KITTITAS COUNTY DEPARTMENT OF PUBLIC WORKS

MEMORANDUM

TO: Dan Valoff, Community Development Services
FROM: Christina Wollman, Planner II *CW*
DATE: October 4, 2011
SUBJECT: Hoff Short Plat SP-11-00010

HOFF SHORT PLAT
PART OF SECTION 9, T. 18 N., R. 17 E., W.M.
KITITAS COUNTY, WASHINGTON

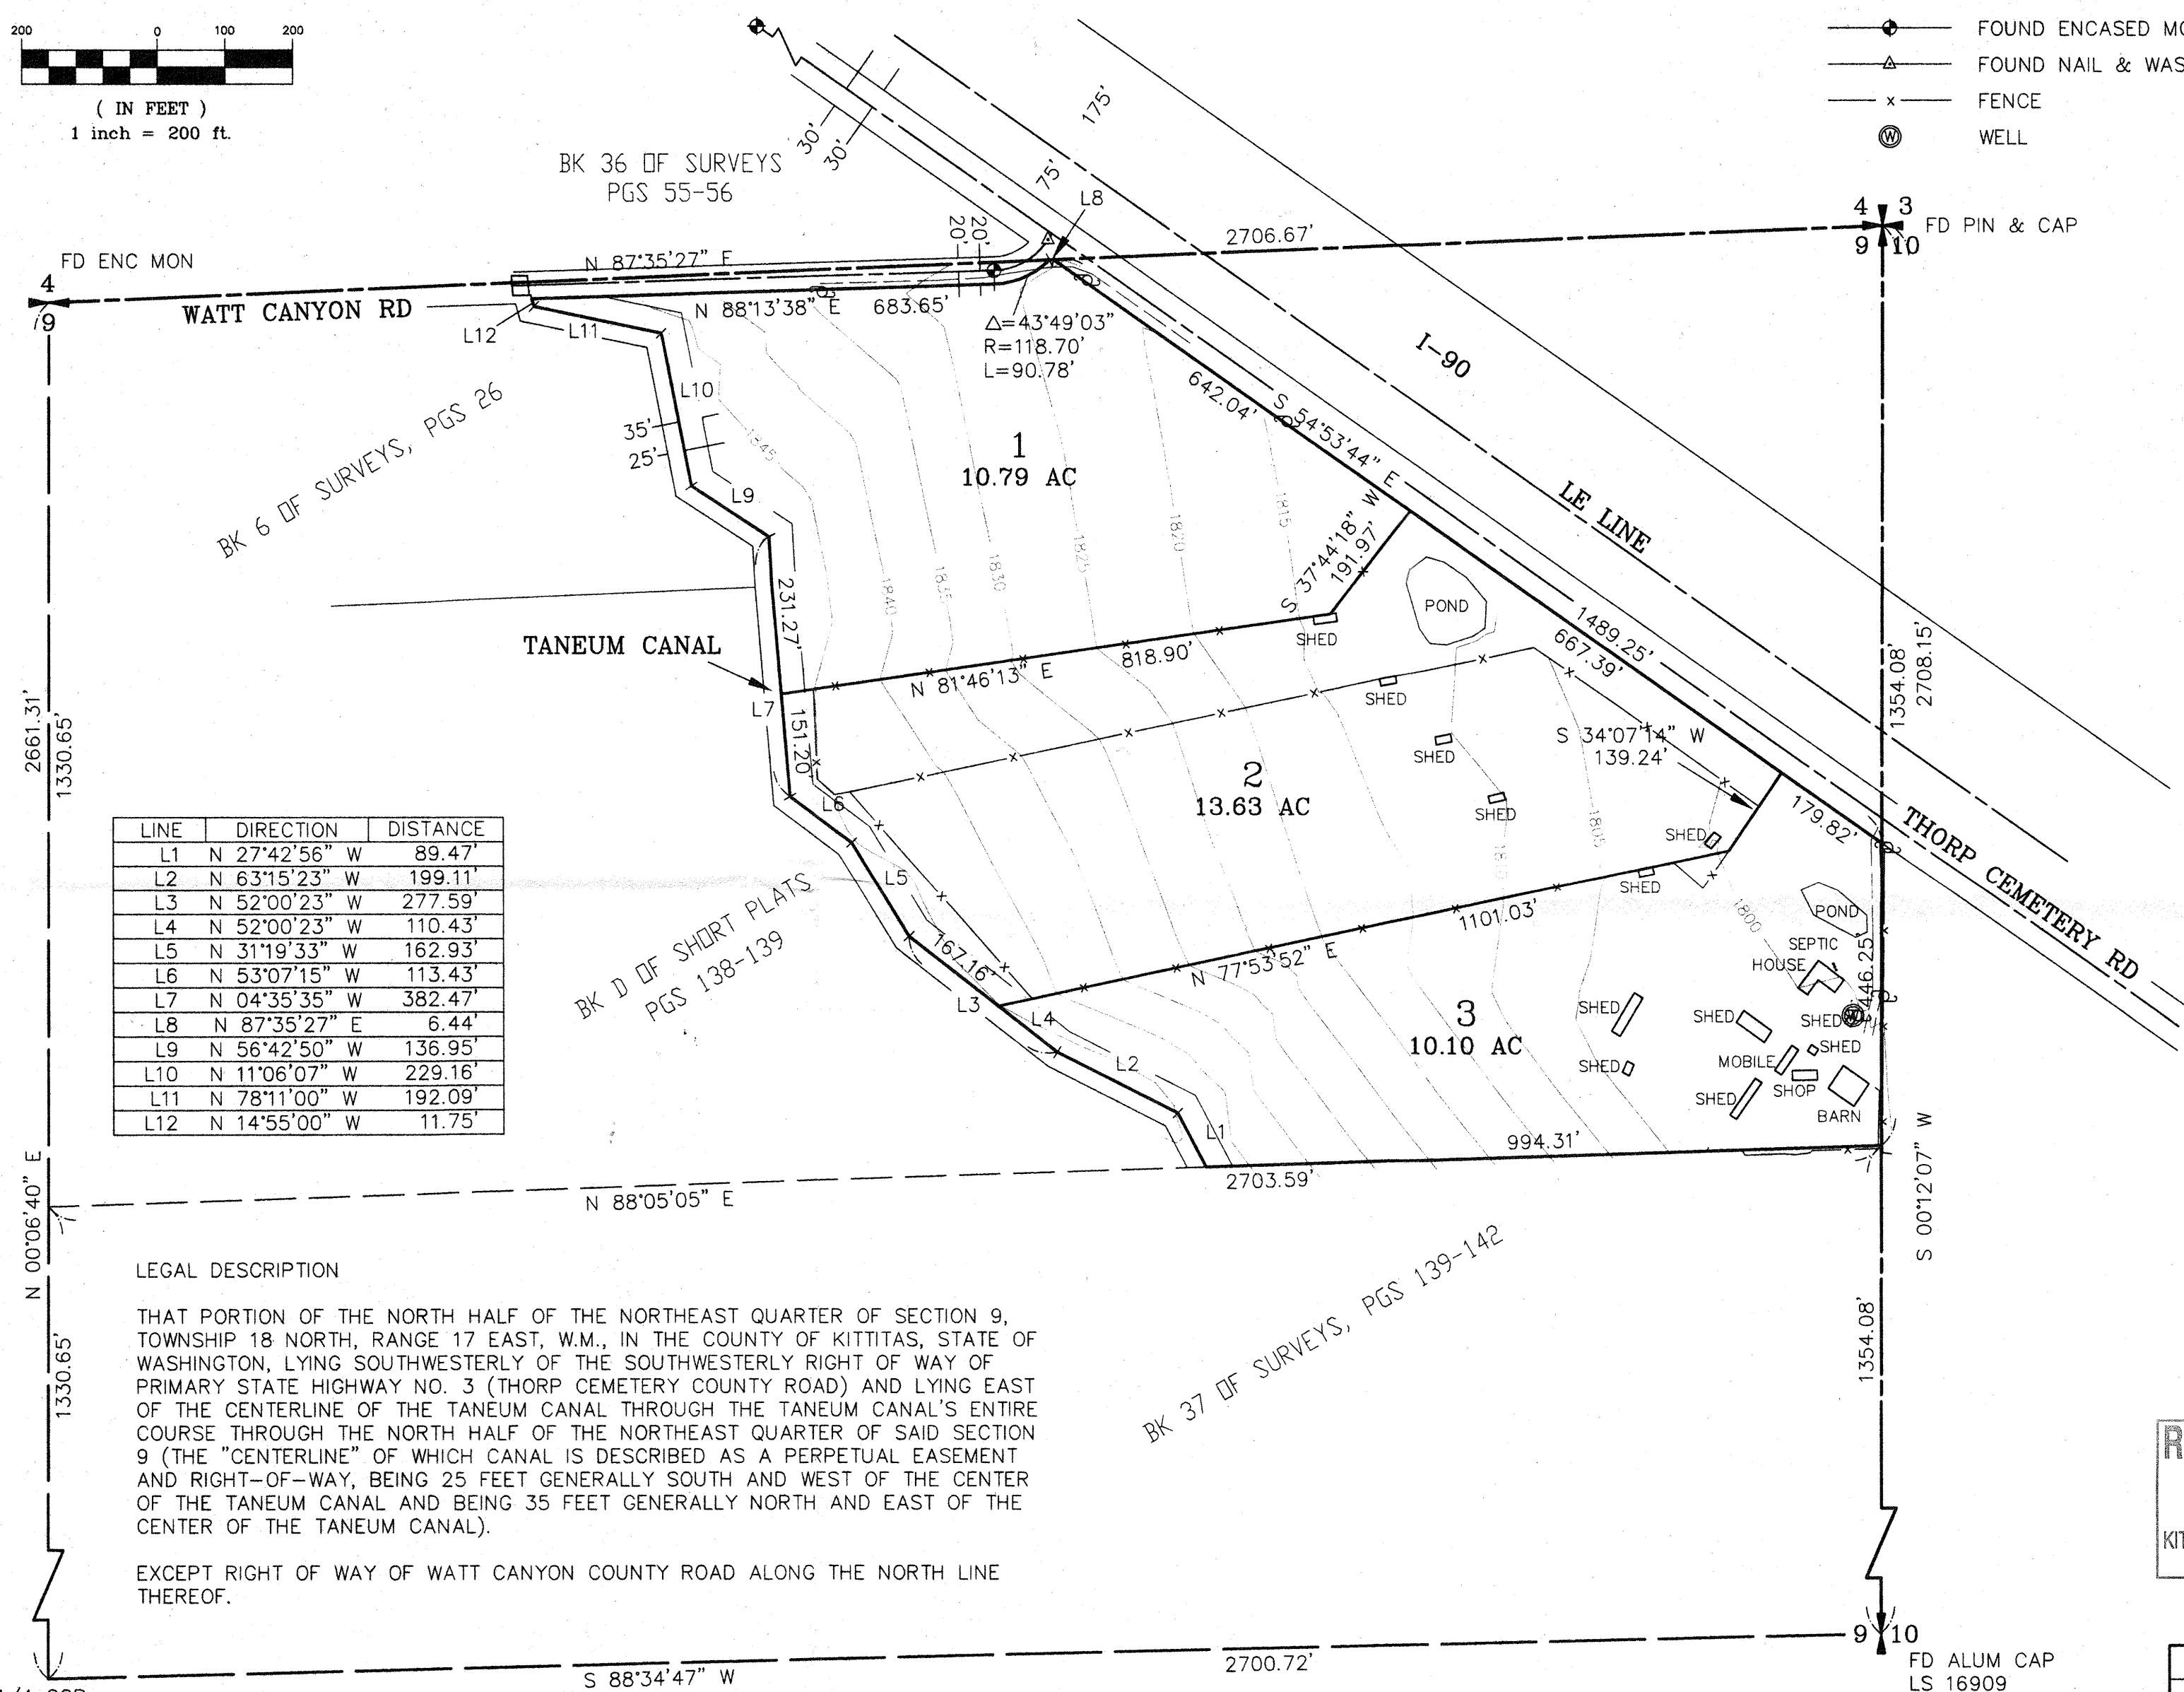
1. Access: County roads serving these lots are Thorp Cemetery Road, a Minor Collector, and Watt Canyon Road, a Local Access. KCC 12.05.030(6) states: Parcel creations which are adjacent to a major or minor collector/arterial (as designated by the Board) shall be provided access other than the arterial if available.

2. Access Locations: Access to Lot 1 shall be from Watt Canyon Road. Access to Lot 2 shall be in a location that meets access spacing and sight distance requirements. Along Thorp Cemetery Road access spacing is 300' and sight distance is 425'. No new approaches onto Lot 3 shall be allowed.
